Sheringham Shoal and Dudgeon Offshore Wind Farm Extension Projects

Draft Statement of Common Ground with National
Highways (Revision D)

Revision D
Deadline 7
July 2023
Document Reference: 12.22

TITLE  
A47 EASTON  
DRAFT  
ACC47 ACCESS DESIGN  
(SHEET 1 OF 2)

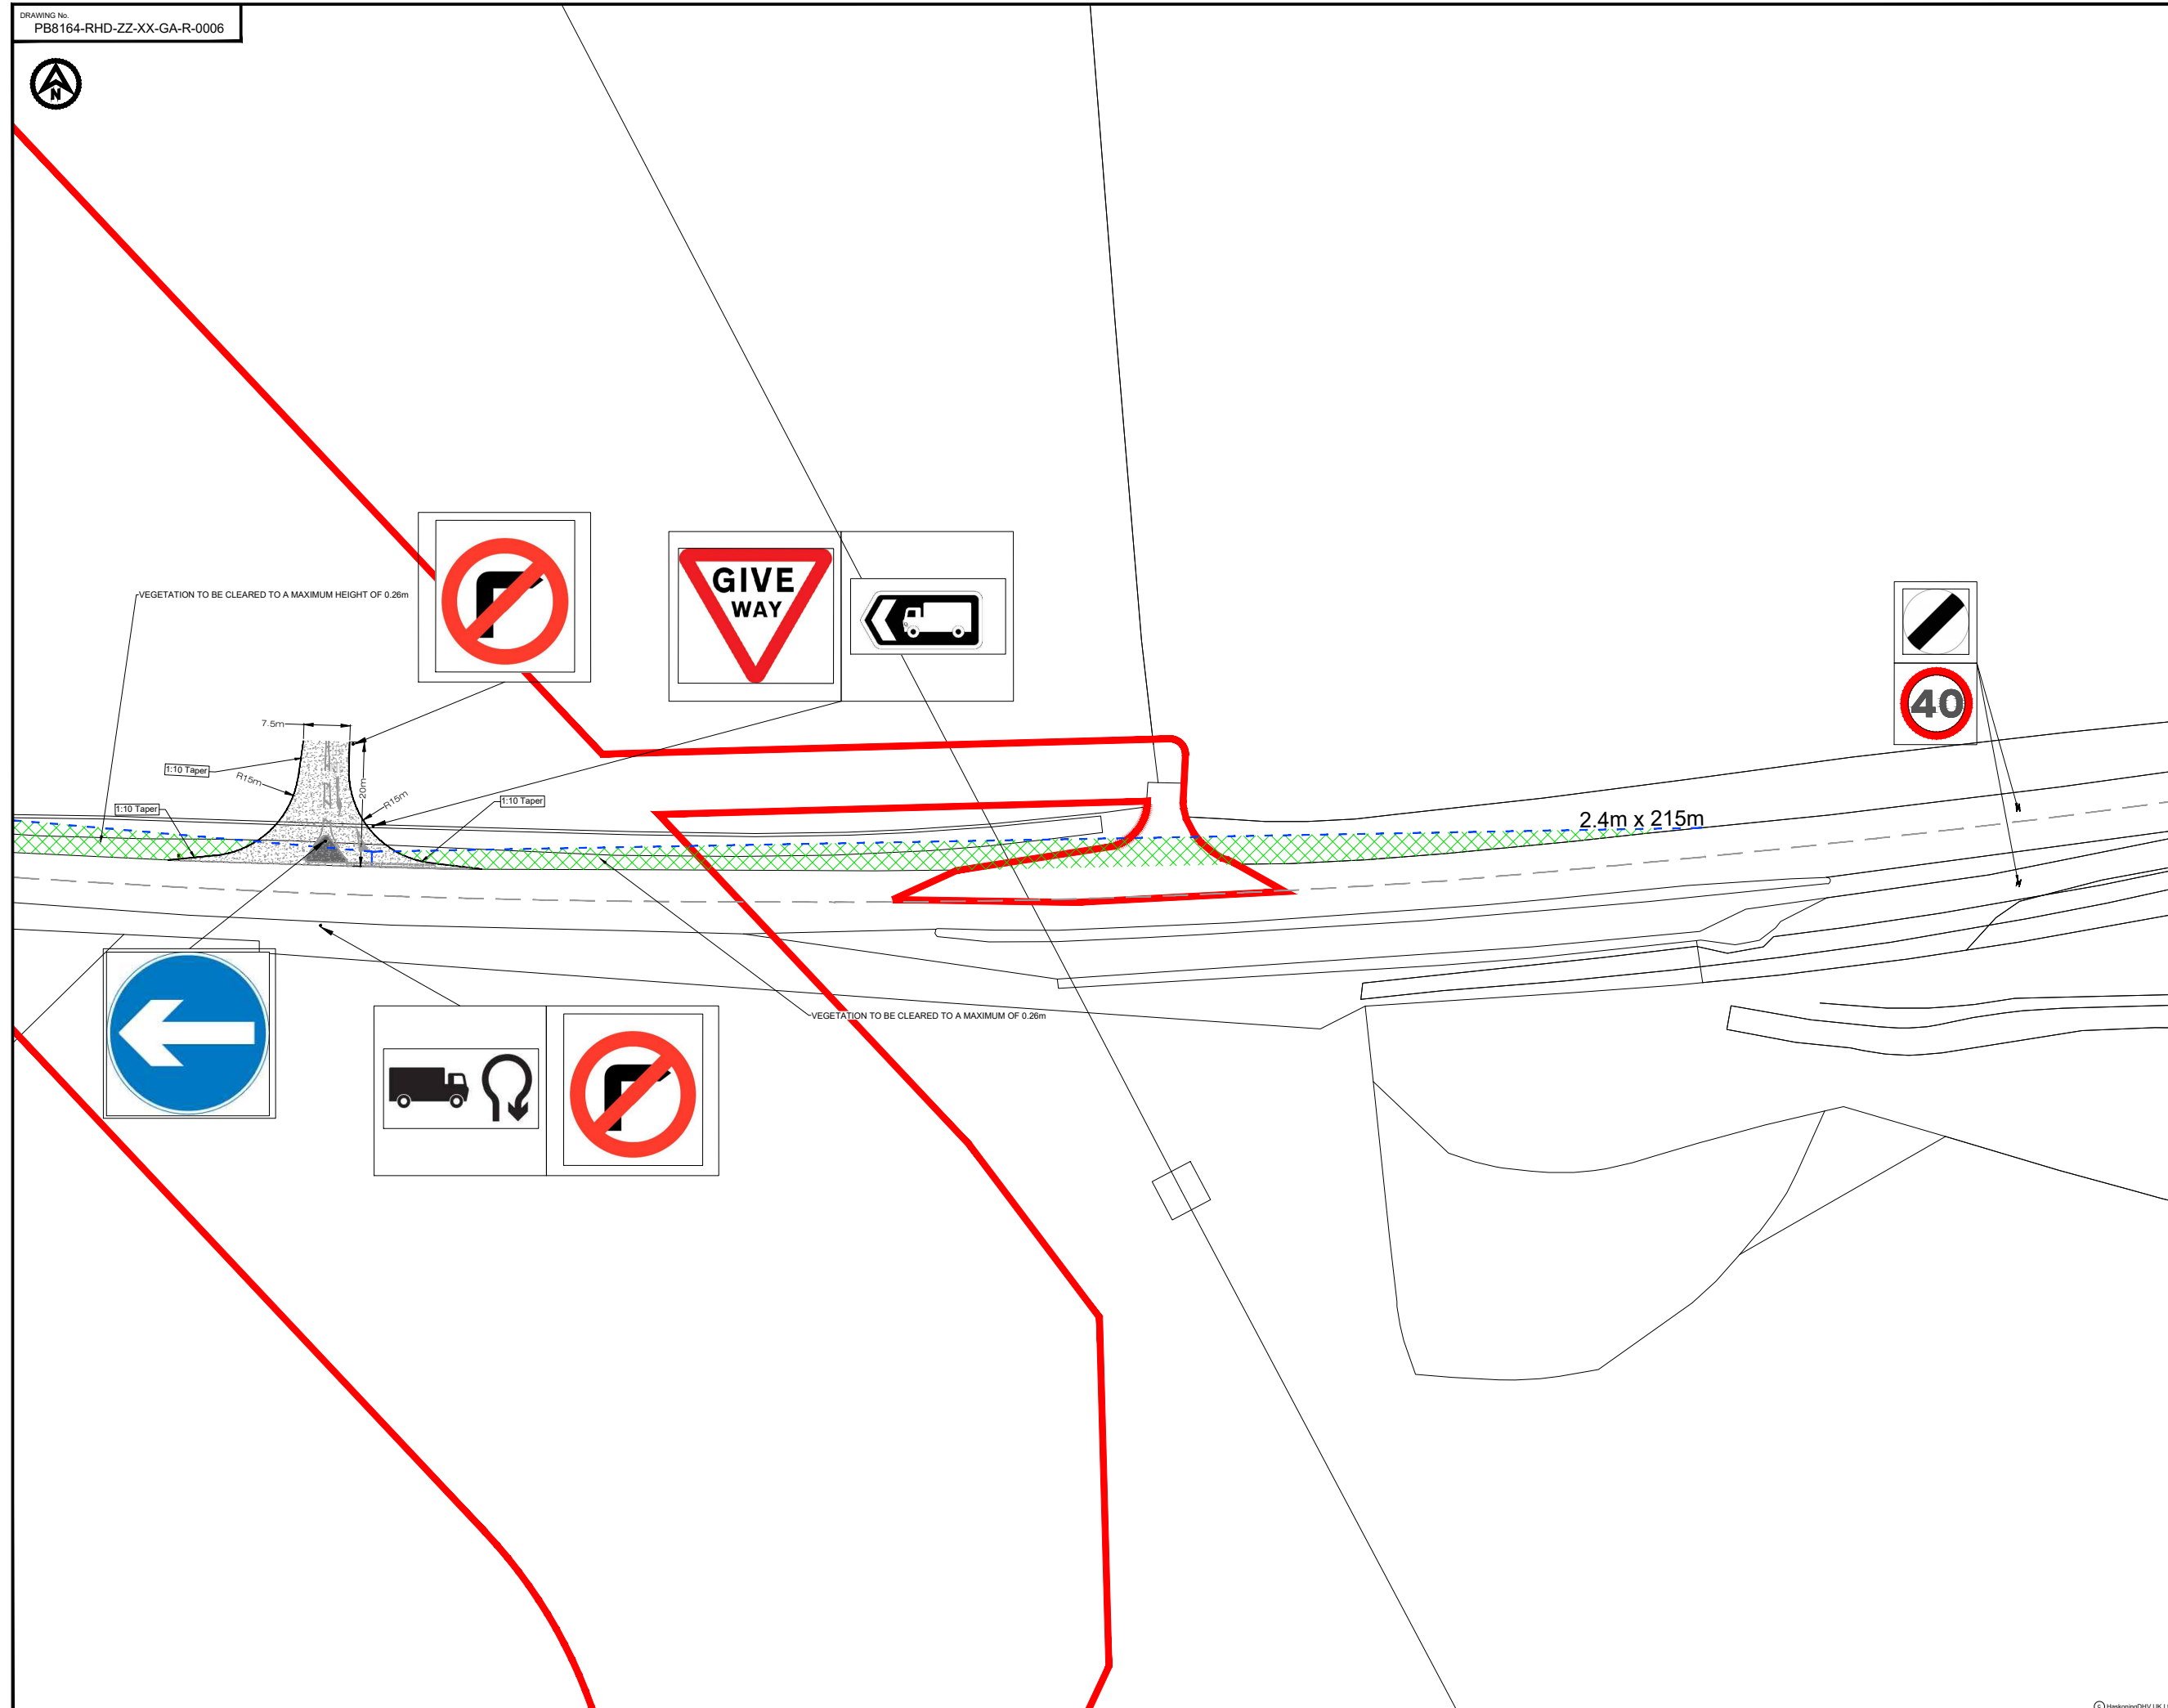
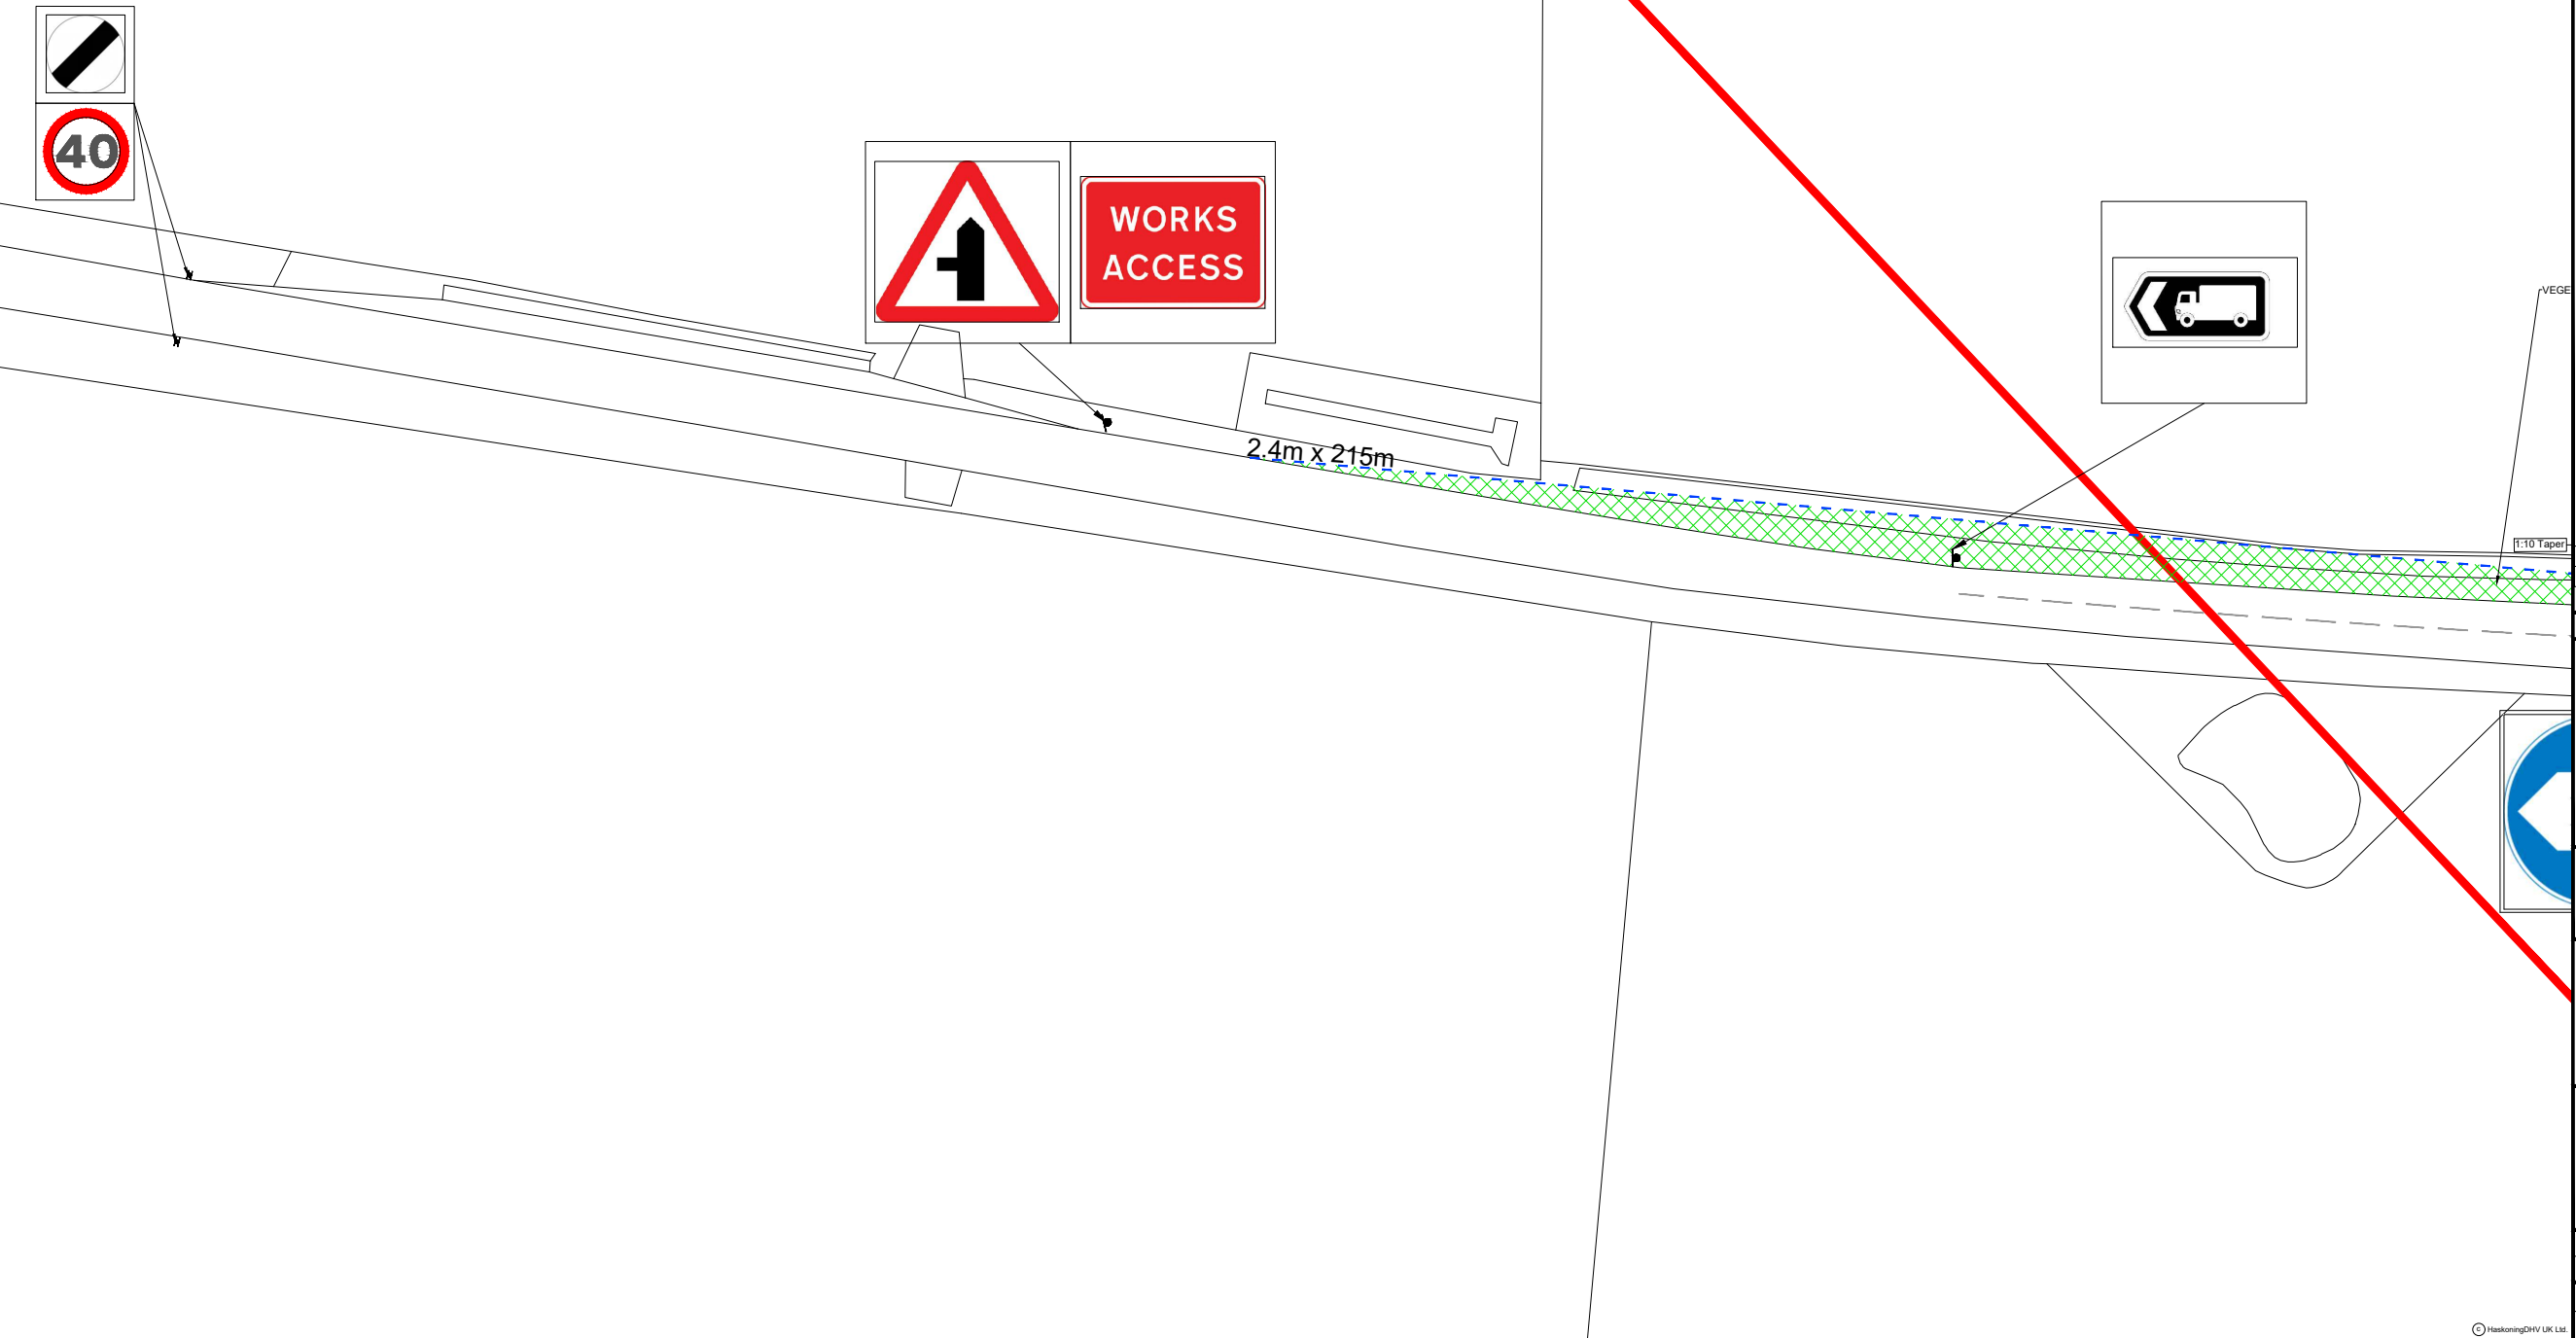
23	The outline design for an access off the A47 is appropriate, as presented in Annex 30 of the Transport Assessment [APP-268 and APP-269]	National Highways agree that the outline design for an access off the A47 (ACC47) is appropriate subject to Stage 1 and 2 Road Safety Audits being carried out post consent. Please note that this access is only usable until the A47 Tuddenham scheme starts construction, or if the A47 Scheme does not go ahead.	<i>Agreed</i>
EIA – Cumulative Impact Assessment (CIA) Conclusions			
24	Cumulative impacts assessment with other windfarms, as presented in Section 24.7 of ES Chapter 24 Traffic and Transport [APP-110], is appropriate based on currently available information and proposed mitigation, impacts are not significant in EIA terms.	National Highways agree that the cumulative impacts assessment with other windfarms, in relation to effects on traffic along the SRN, as presented in Section 24.7 of ES Chapter 24 Traffic and Transport [APP-110], is appropriate based on currently available information and proposed mitigation, impacts are not significant in EIA terms.	<i>Agreed</i>

29	The access concept design for access ACC47 is appropriate and that detailed access designs can be developed and agreed with National Highways prior to the start of construction, secured under Requirement 16 of the draft DCO [AS-009].	National Highways agree that the access concept design for access ACC47 is appropriate, subject to Stage 1 and 2 Road Safety Audits to be carried out post consent, and that detailed designs can be developed and agreed with National Highways	<i>Agreed</i>
